Application No: AL/35/26/RES
Site Address: Land rear of Meadow Way Westergate
Description of works: Approval of reserved matters following outline consent AL/178/22/OUT for appearance, landscaping, layout and scale for the construction of 89 No. residential dwellings, together with open space, landscaping and associated infrastructure, with access taken from Meadow Way (resubmission following AL/137/24/RES). This application is in CIL Zone 3 and is CIL Liable as new dwellings.

Thank you for your internet representation made on 24th June 2026 which has been recorded as an objection with the comments as follows:

Project Land Rear of Meadow Way, Westergate
Drawing Affordable Housing Layout

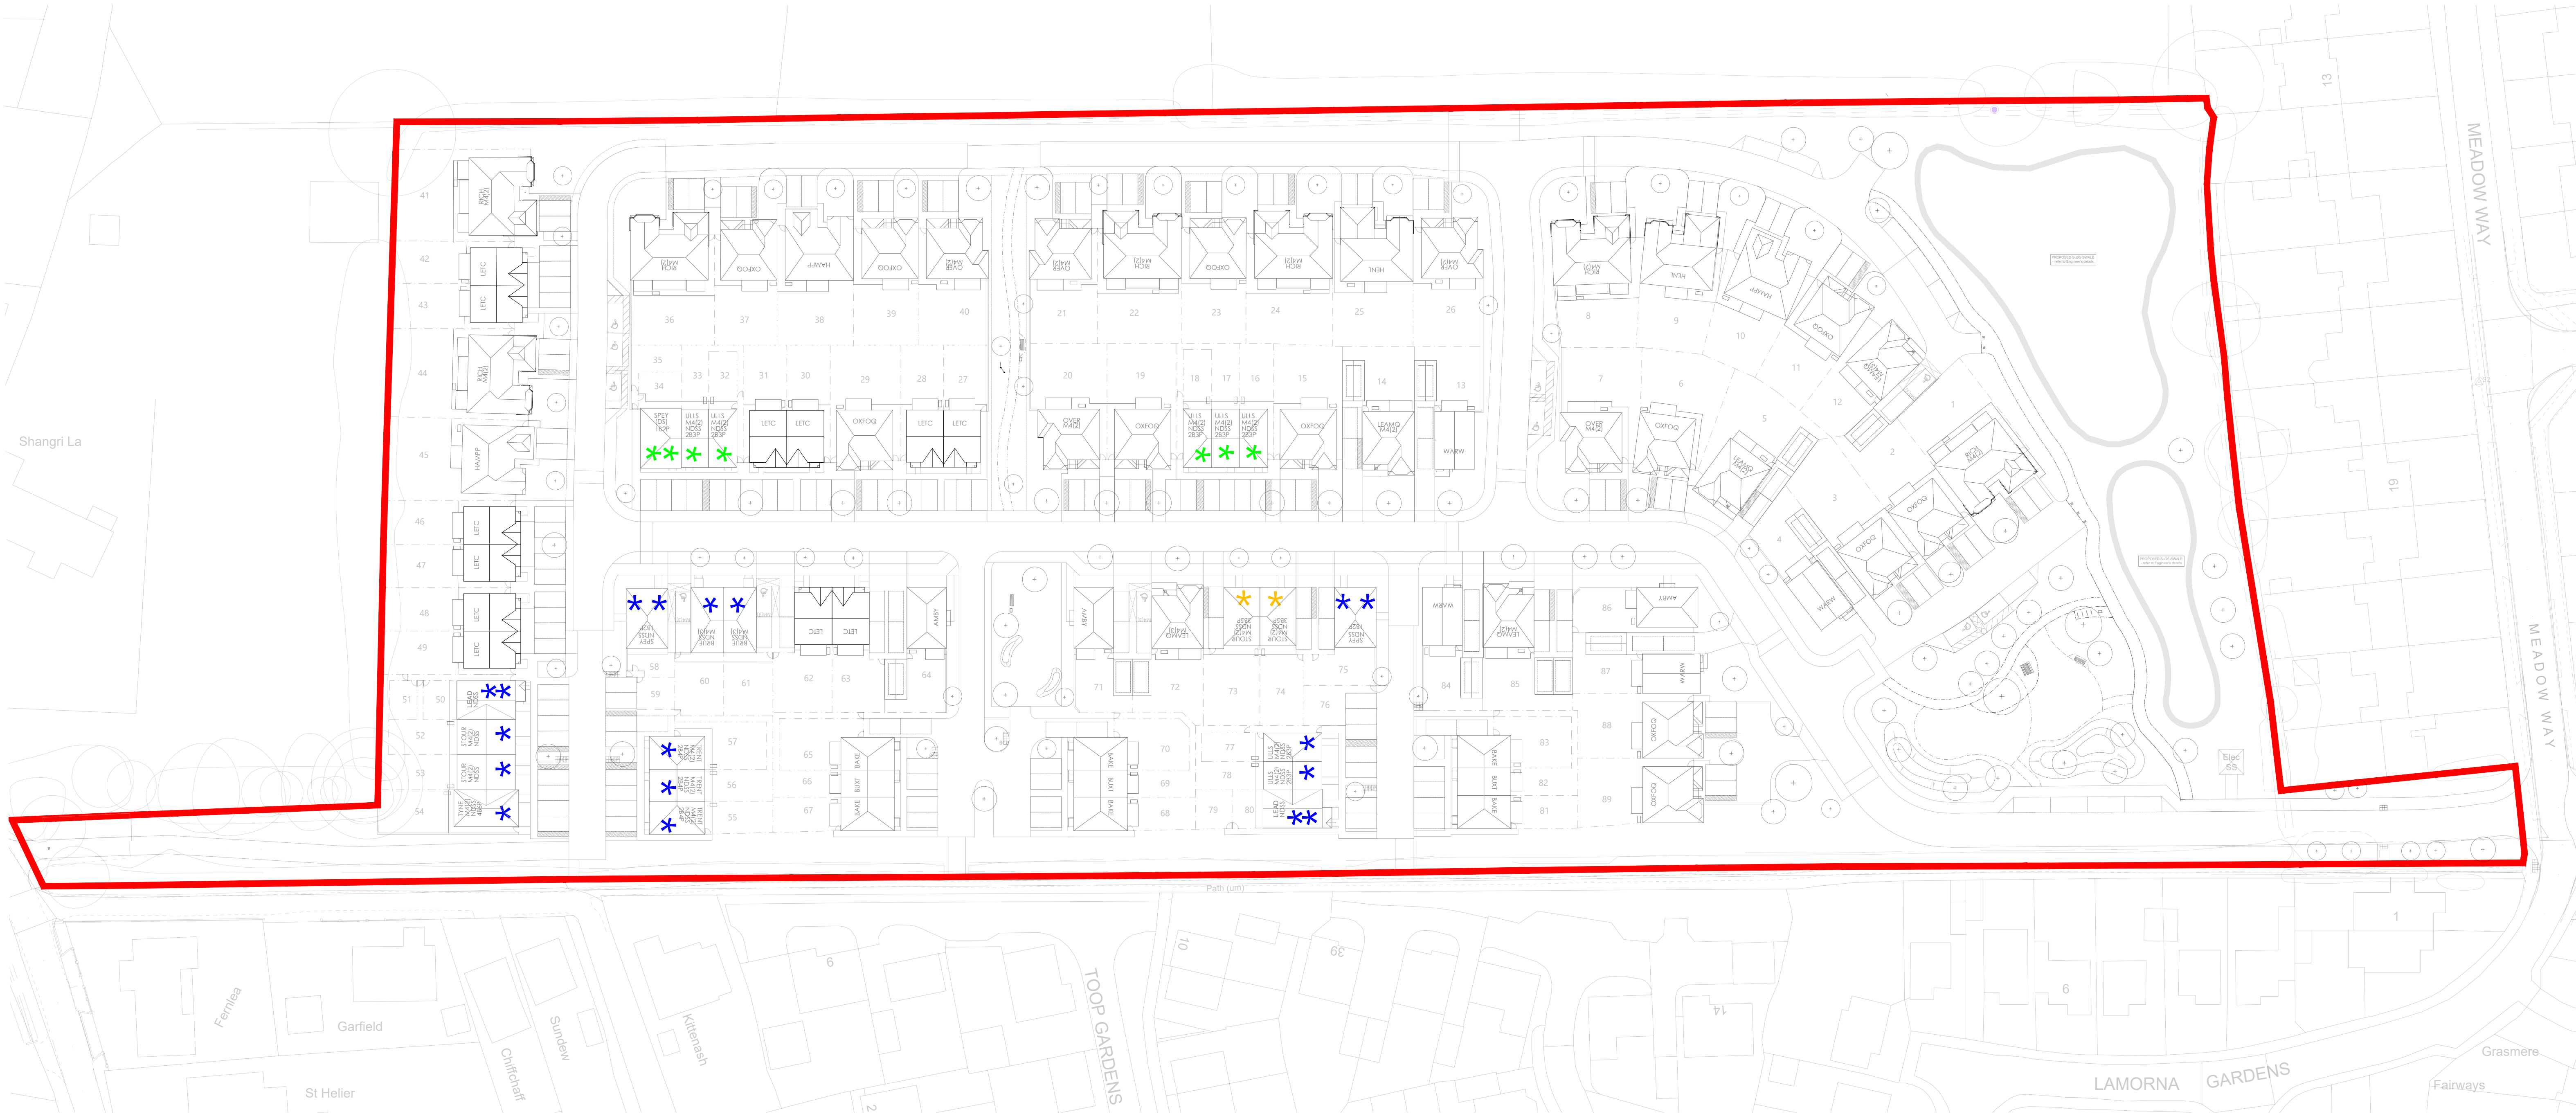
There is very little difference between the location of the Affordable/Social Housing on this new application when compared to the previous application. All the Affordable Housing is concentrated along the footpath boundary on the Southern side of the site. We live exactly opposite the exit point of this footpath onto Hook Lane. It is very likely that should this planning application be approved, then there could be an unhealthy concentration of noise disturbances plus bad behaviour along this footpath, which would inevitably spill onto the quiet and rural Hook Lane at this point.

2. There are 4 access points onto this footpath proposed in the new application. This is too many and would only make the problems described above more likely to occur.

3. The combination of the Affordable Housing, the footpath immediately adjacent to ALL the Affordable Housing plus the 4 access points onto the footpath make a perfect recipe for an undesirable result. This could be a concentration of youths along the footpath at any time of day and particularly at night who could cause noise disturbances and bad behaviour which would be disruptive to the peace and tranquility that exists along Hook Lane at this location presently.

The obvious solution to my concerns is to spread or scatter the Affordable Housing at various locations around the site, and NOT just on the edges. This is NOT impossible to do. I am shocked that the present plan was even presented in this form. It is so obvious that the Affordable Housing has just been thrown down next to the footpath, as far away from the rest of the development as possible. What about Community Integration ? All that this plan would achieve is the creation of a ghetto along the southern edge of the site with no chance of integration. The rest of the site would have the style of exclusivity and privilege which could well breed resentment and dissatisfaction among some elements of the Affordable Housing community. Is this what the planners and Arun District Council want ? Dispersal around the site of the Affordable housing would ensure a more diluted effect and prevent undesirable ghettoisation in one section.
